Rezoning Transportation Analysis

Petition Number: 2020-012

Date	Description
02-18-2020	First Review
04-16-2020	Second Review

SHEET NUMBER
RZ-1

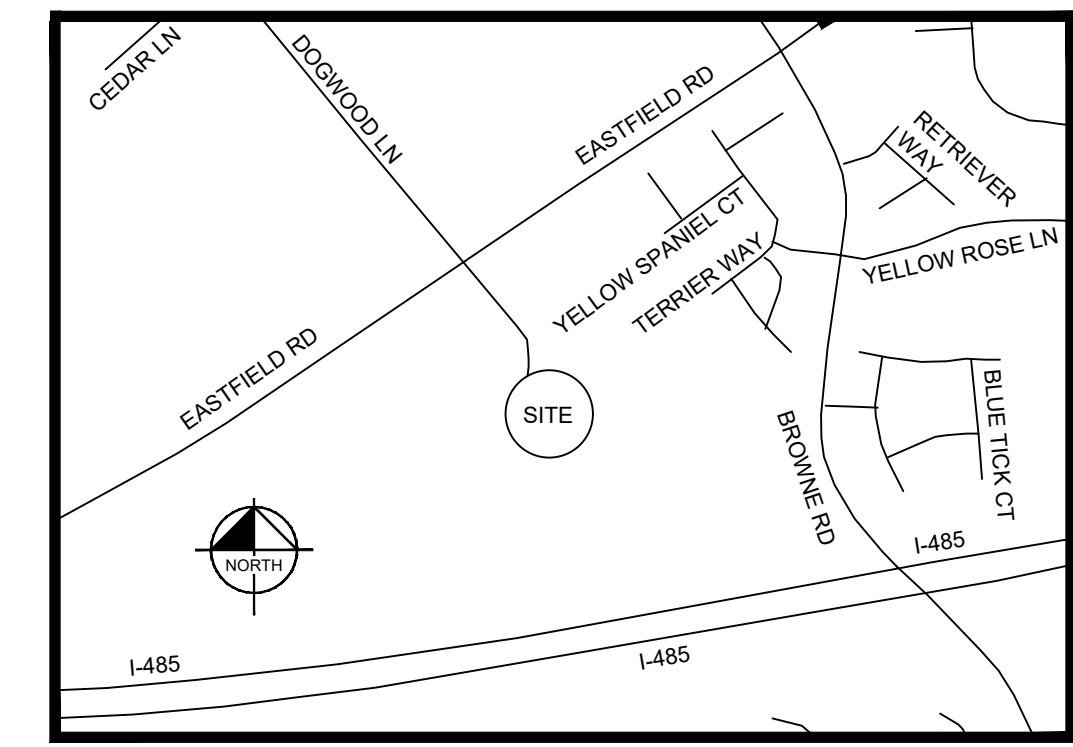
3. The petitioner should revise the site plan and conditional note(s) to commit to dedicate 35' of right-of-way from the road centerline to meet CRTPO guidelines for a minor thoroughfare. The site plan should label and dimension the right-of-way from the road centerline.

5. The petitioner should revise the site plan and conditional note(s) to construct a left turn lane on Eastfield Road into Road "A".
6. The petitioner should revise the site plan and conditional note(s) to construct a left turn lane on Browne Road into Road "B".
- ~~7. CDOT is requesting the petitioner revise the site plan and conditional note(s) to create a three-lane section on Road "A" where it connects to Eastfield Road as shown below.~~

8. The petitioner should revise the site plan to add a note specifying dedication and fee simple conveyance of all rights of way to the City before the site's first building certificate of occupancy is issued. CDOT requests right of way set at 2' behind back of sidewalk where feasible.
9. The petitioner should revise the site plan to add a note specifying all transportation improvements will be approved and constructed before the site's first building certificate of occupancy is issued. The petitioner may phase transportation improvements if said improvements and phasing are explicitly described in site plan notes.
10. ~~Resolved~~ Sample format for comment that is resolved
